# Submissions Report

EQUIS ENERGY (AUSTRALIA) PROJECTS (NGUMI 4) PTY LTD AS TRUSTEE FOR EQUIS ENERGY (AUSTRALIA) NGUMI 4 HOLDING TRUST PTY LTD

MAY 2024

This Submissions Report relates to the proposed standalone battery energy storage system (BESS) with a storage capacity up to 300MW and 600MWh discharge capacity, and connection to the existing Tamworth substation via underground transmission cable, and ancillary works at 474 Calala Lane, Calala (the site) and has been prepared on behalf of Equis Energy (Australia) Projects (Ngumi 4) Pty Ltd as trustee for the Equis Energy (Australia) Ngumi 4 Holding Trust (Equis) (the Applicant). The project has been amended to address the concerns raised in submissions, and a description of the amendments proposed are outlined in the Amendment Report submitted in conjunction with this Submissions Report. This Submissions Report has been prepared to address the matters raised by the Department of Planning, Housing and Infrastructure (DPHI), public agencies, Council, and objectors. The State Significant Development Application (SSDA) was lodged with the DPHI (formerly the DPE) in November 2023 (SSD-52786213).

Site plan

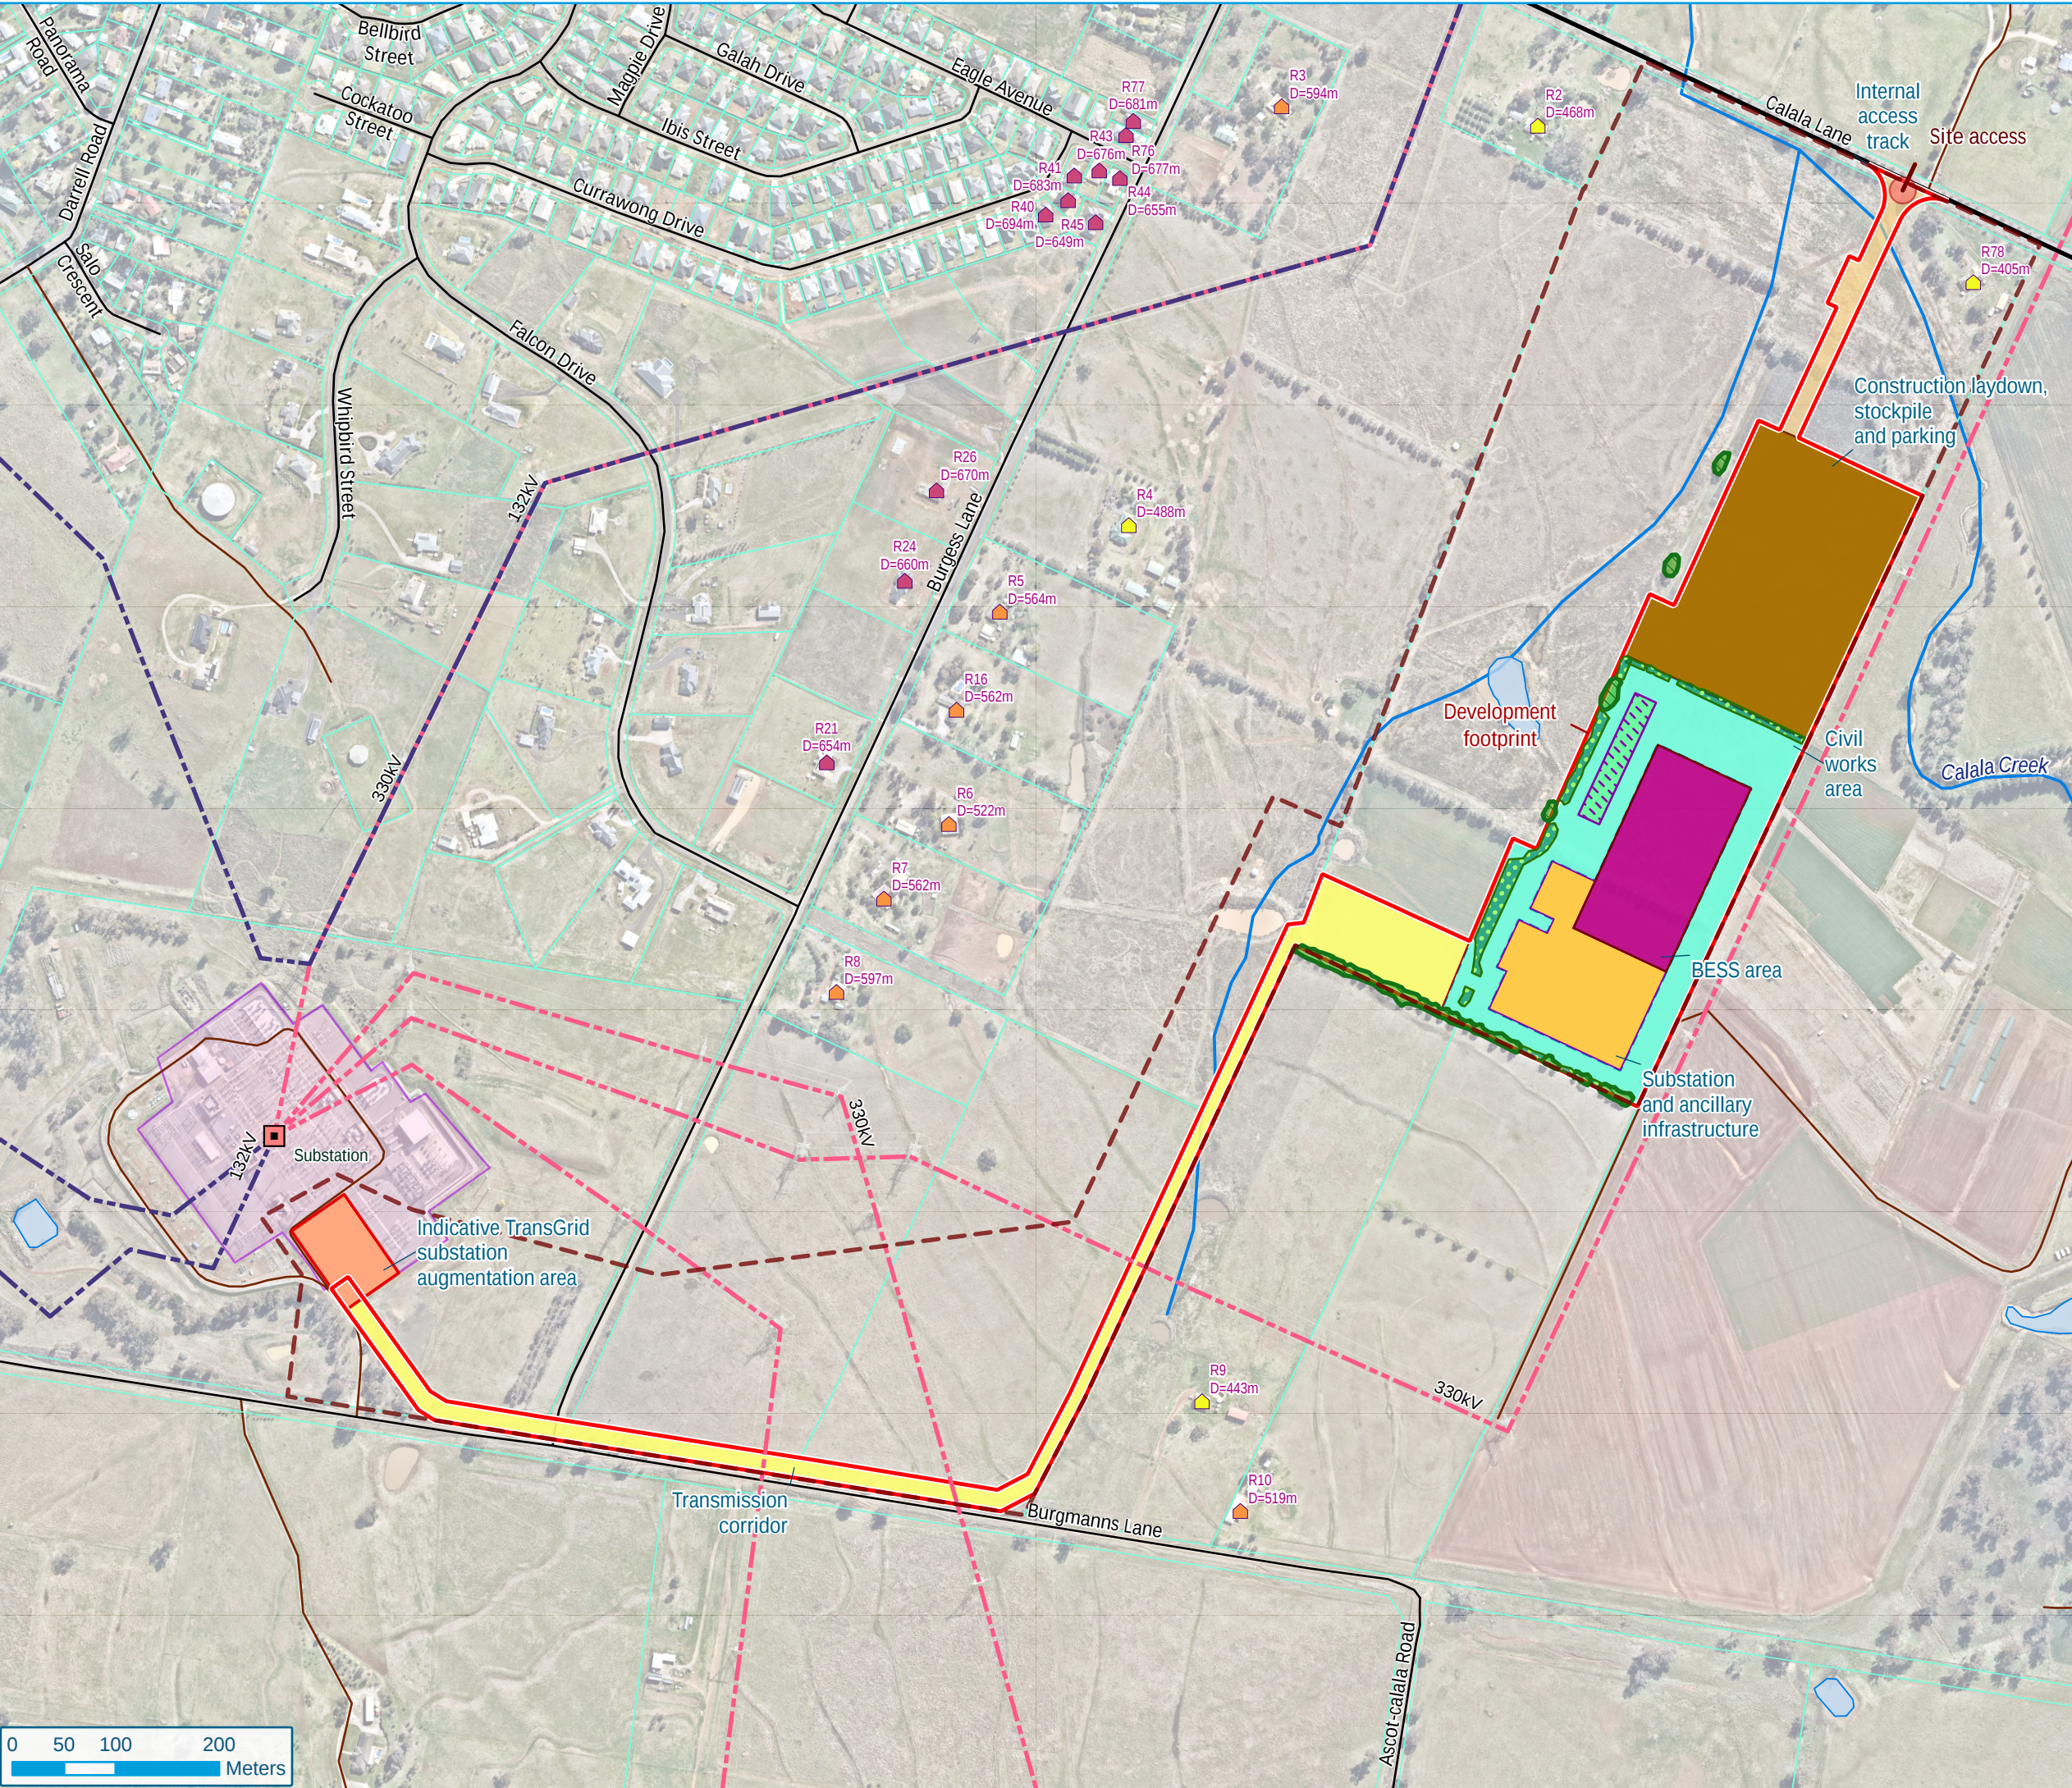
<p>Regional Plan 2041 which identifies the potential for the region to become a renewable energy hub of NSW.</p> <p>Although most of the Tamworth Region is outside the New England Renewable Energy Zone (REZ), its proximity has led to a large interest in establishing renewable energy projects in the area. It is noted that this Project does not fall within the New England REZ but would be an integral part of the overall renewable energy framework associated with the broader New England region.</p> <p>Council recognises the potential benefits to the community of a project of this scale with a capital investment value exceeding \$30 million. Council also recognises there will be impacts arising from the Project, particularly for local residents. With this in mind, the following comments are raised regarding this specific project.</p>	
	<p>1. <u>Visual Impact</u></p> <p>It is noted that the Landscape and Visual Impact Assessment (LVIA) Report found that the Project will have low to moderate visual impact on non-associated dwellings and public viewpoints. Mitigation measures have been recommended in the Report to limit the visual impact from the Project. Such mitigation measures include but are not limited to the retention of existing vegetation and new supplementary planting, colour recommendations and implementation of lighting design principles. Council supports the identified mitigation measures and advises that the Proponent strongly consider any additional concerns raised by community members within visual proximity to the development site.</p>	<p>Council's comments on the LCVIA are noted. The proposal has been amended to reduce the BESS footprint and incorporate various additional measures to mitigate visual impact of the proposed development, including a grassed mound to the west of the BESS, and additional planting of trees in accordance with the plans submitted with the revised LCVIA. These additional mitigation measures are considered sufficient for the purposes of mitigating visual impacts of the proposal.</p>
